From: [Matt Leighton](#) on behalf of [Town Planning LNE](#)
To: [Planning](#)
Subject: Ref 6/2021/0181/MAJ - Hybrid application, Former Shredded Wheat Factory, Broadwater Road, Welwyn Garden City
Date: 24 August 2021 13:12:29
Attachments: [image001.png](#)
[Ref 6/2021/0181/MAJ - residential development Former Shredded Wheat Factory Broadwater Road Welwyn Garden City.mxd](#)

Network Rail Consultation Response

FAO:	Ms Iqraa Malik
Date:	24 August 2021
Application reference:	6/2021/0181/MAJ
Proposal:	Hybrid planning application
Location:	Former Shredded Wheat Factory, Broadwater Road, Welwyn Garden City, AL7 1RR

Figure 5.1: Proposed Site Layout

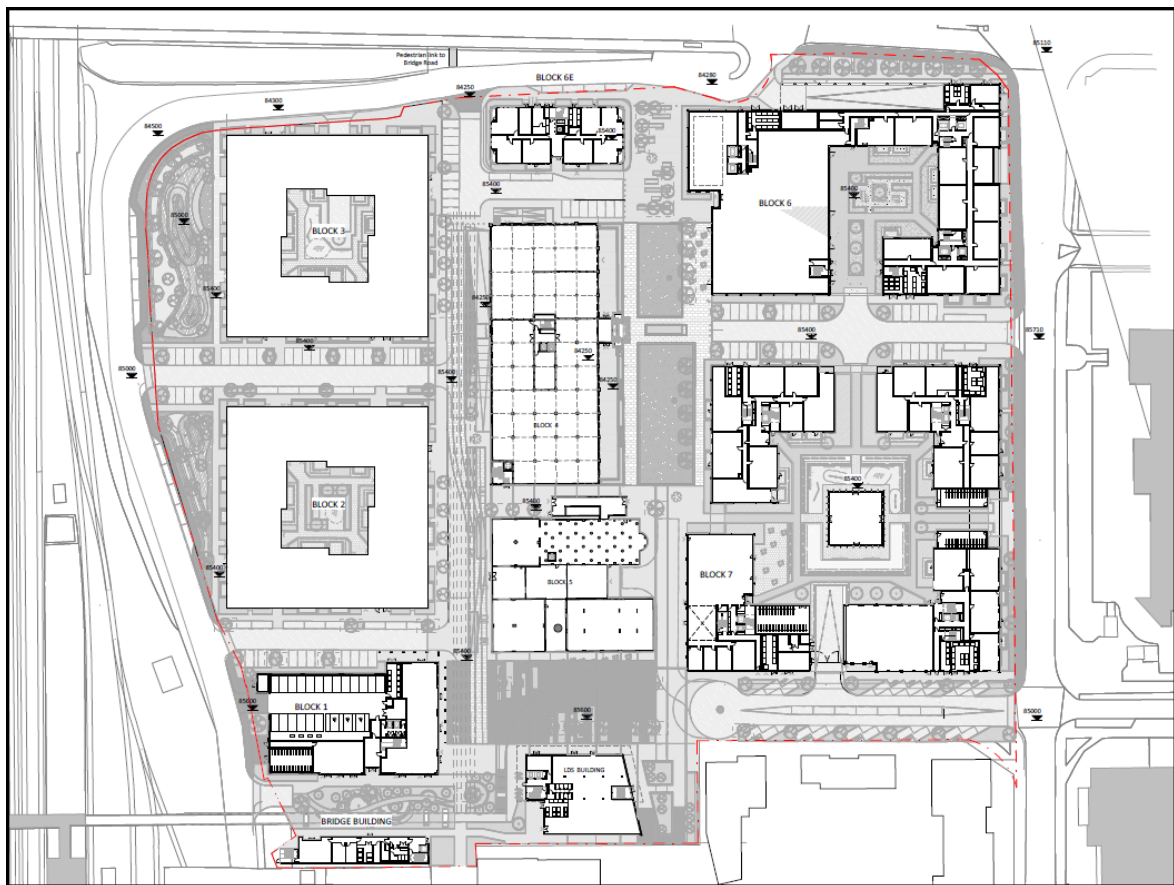
Following assessment of the further details supplied in support of this application, Network Rail would reiterate our previous comments made in our response of 22 March 2021 (attached) as the details provided do not appear to address these points. In particular, we would reiterate that the proposed access road is not capable of taking the proposed level of traffic unless brought up to an adoptable standard.
